From: Hebe Smith on behalf of Planning.Responses
Sent: 09 August 2023 11:51
To: Planning Scanning
Subject: FW: Planning Re-Consultation on: BE/53/22/DOC
Attachments: BE-53-22-DOC Unit 9 Saltbox Comment Tracker.docx; BE-53-22-DOC Unit 9 Saltbox Consultation 4 of 2 - Template.docx

Application No:	BE/53/22/DOC
Registered:	26th May 2022
Site Address:	Unit 9 Salt Box Field Land off Rowan Way Bersted PO22 9NW
Grid Reference:	493949 101573
Category:	Discharge of Condi
Description of Works:	Approval of details reserved by condition imposed under BE/135/18/PL relating to conditions (Full Application) 14- Maintenance and Management of Surface water drainage, 37- details of all fixed plant, machinery and equipment associated with air moving equipment & 42- details of PVs

Application Reference: BE/53/22/DOC Site Name: Unit 9 Salt Box Field Land off Rowan Way Bersted PO22 9NW	Initial Issue Date: 08/08/2023 Issue Date: 08/08/2023 Reviewer Reference: ADC/EXT1a
---	---

Engineers Comments Regarding Surface Water Drainage

Basic Silt Trap by Polypipe Component Detail

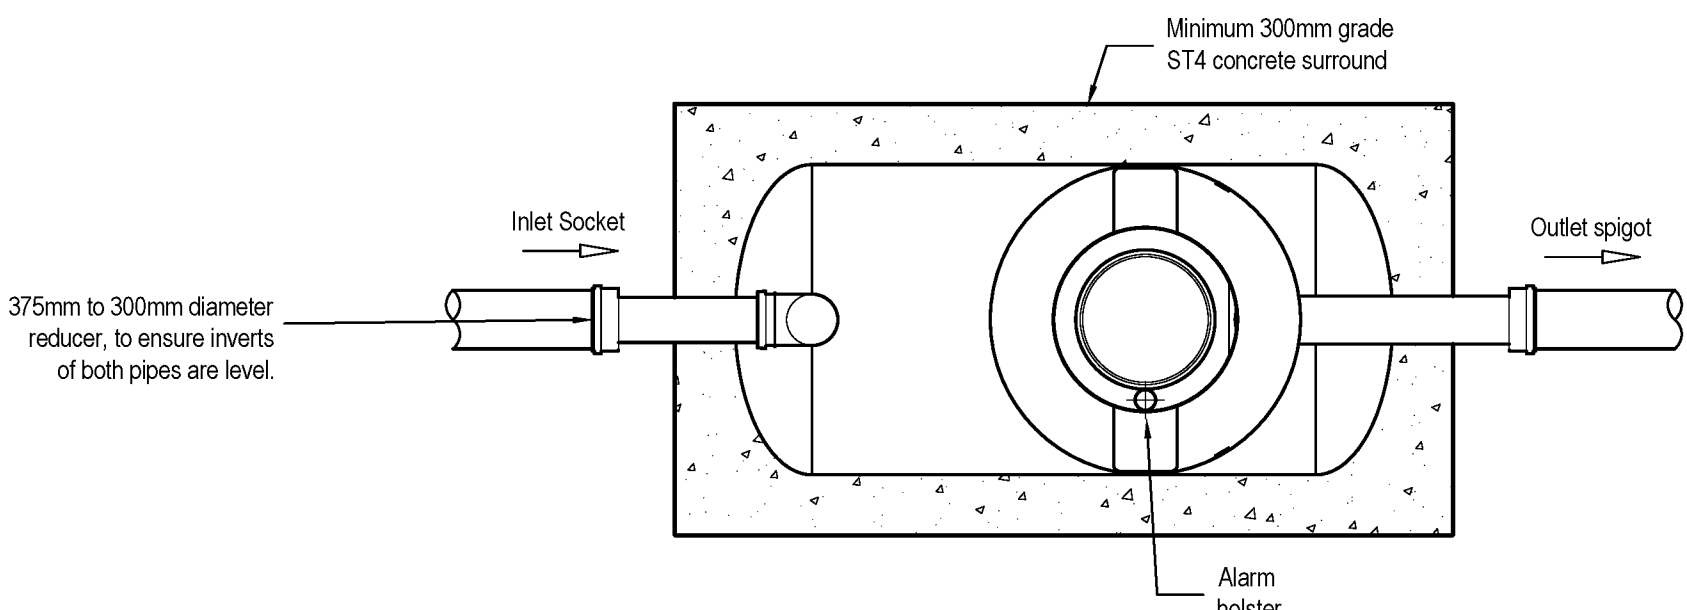
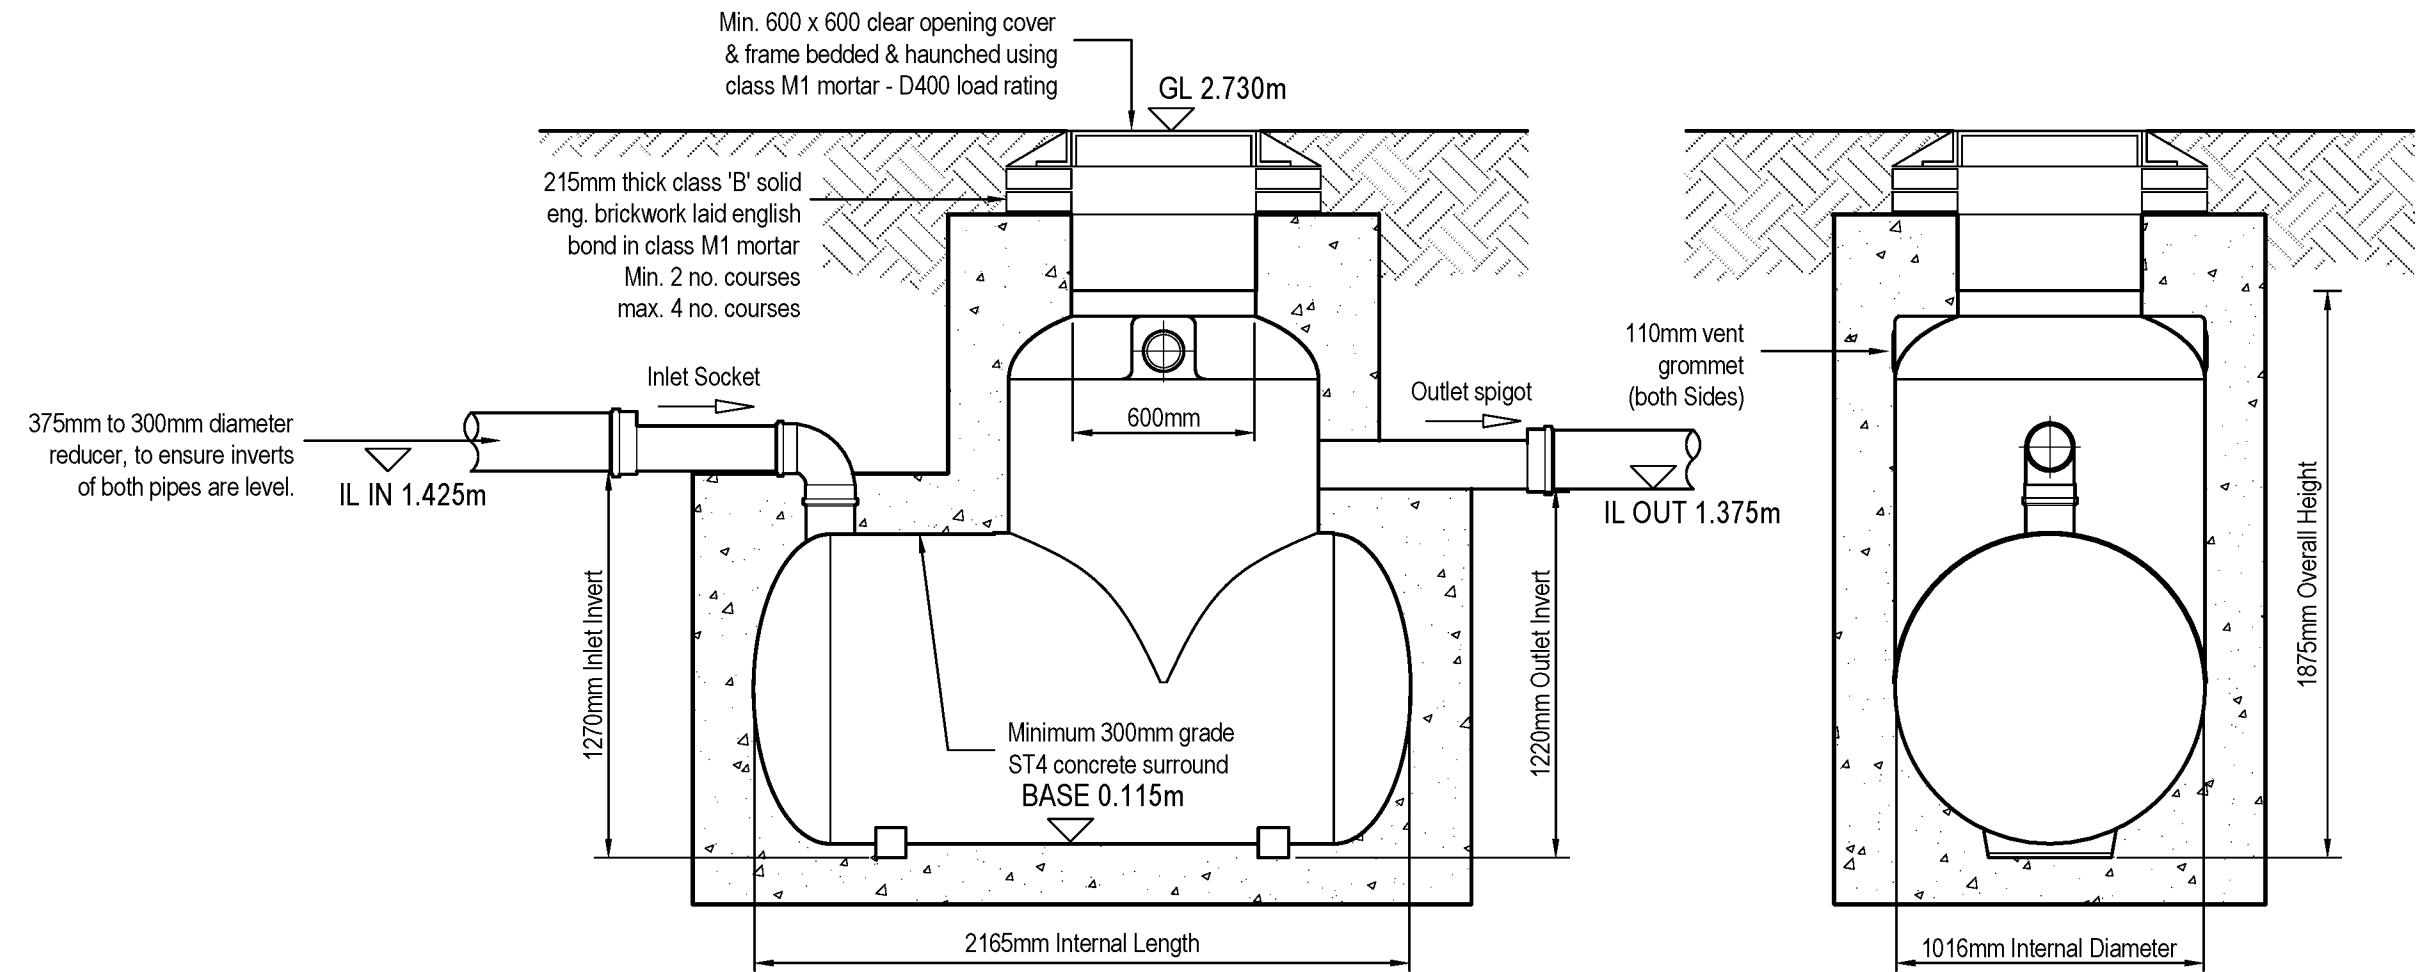
ADC Drainage Comments	Designer Response	ADC Drainage Comments 8/8/2023		
Date					
Condition Number: 14					
1.	Construction Details of the washdown silt box needs to be provided- updated comments 26/04/23 – this information is still outstanding. The information provided in the updated Manual is just the product information brochure from Kingspan. A construction detail of this site box needs to be produced in relation to the site-specific drainage network, clearly identifying the invert connection levels and cover levels.	Updated Drainage Management Report (4 th May 2023)	We have review the updated information and can now confirm this addresses our previous comment

Comments
Following the review of the updated Drainage Management Report (4th May 2023) we can confirm that this has now addressed our previous outstanding queries and therefore can recommend discharging condition 14. List of approved drawings and documents: 114378-Unit 9, Saltbox, Bognor Regis – Drainage Management and Maintenance Report – 4th May 2023 – Revision 1.3

Hydrobrake Manhole in Tubosider Tank Construction Detail

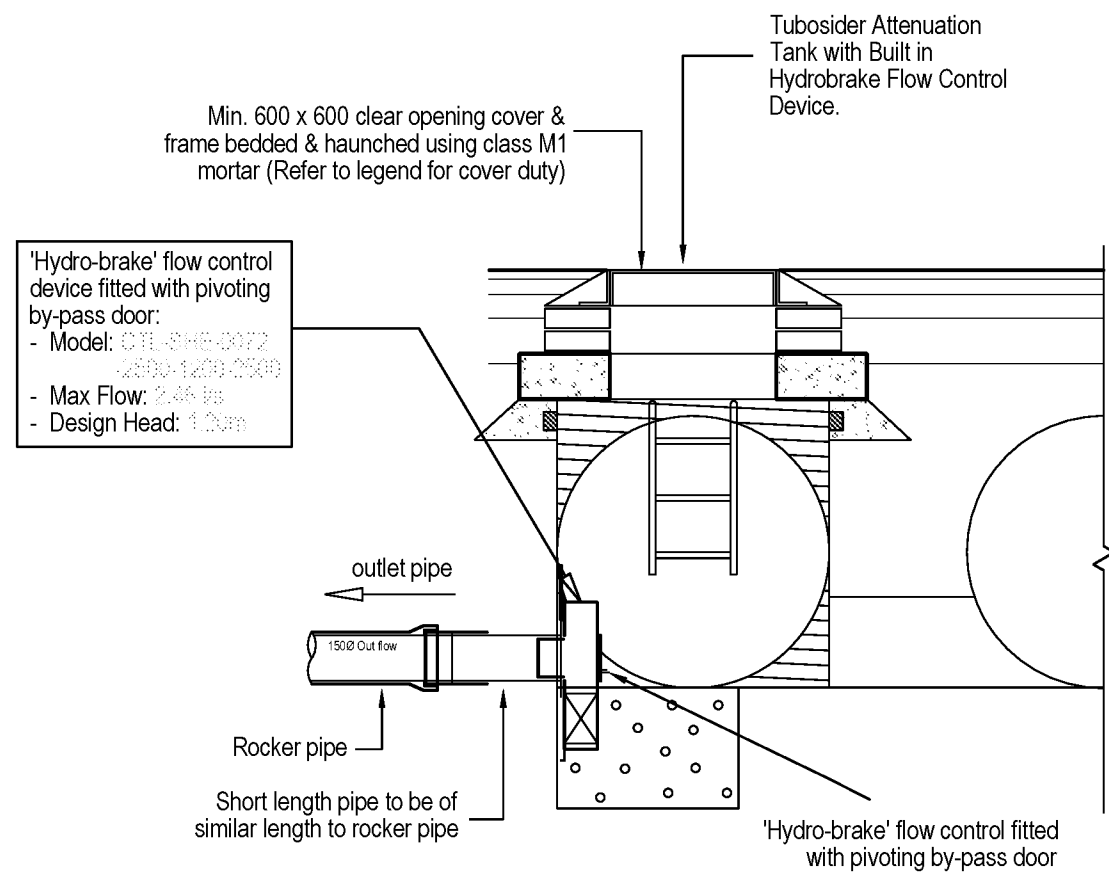
2.	A construction detail on the Hydrobrake manhole needs to be provided and showing clearly how it ties into the proprietary attenuation system, this is important to ensure that future maintenance requirements within this manhole is clear- updated comments 26/04/23 – this information has still not been provided, the detail is not clear on how the Hydrobrake interface and will be fitted within the tank and chamber. Further details are required.	Updated Drainage Management Report (4 th May 2023)	We have review the updated information and can now confirm this addresses our previous comment
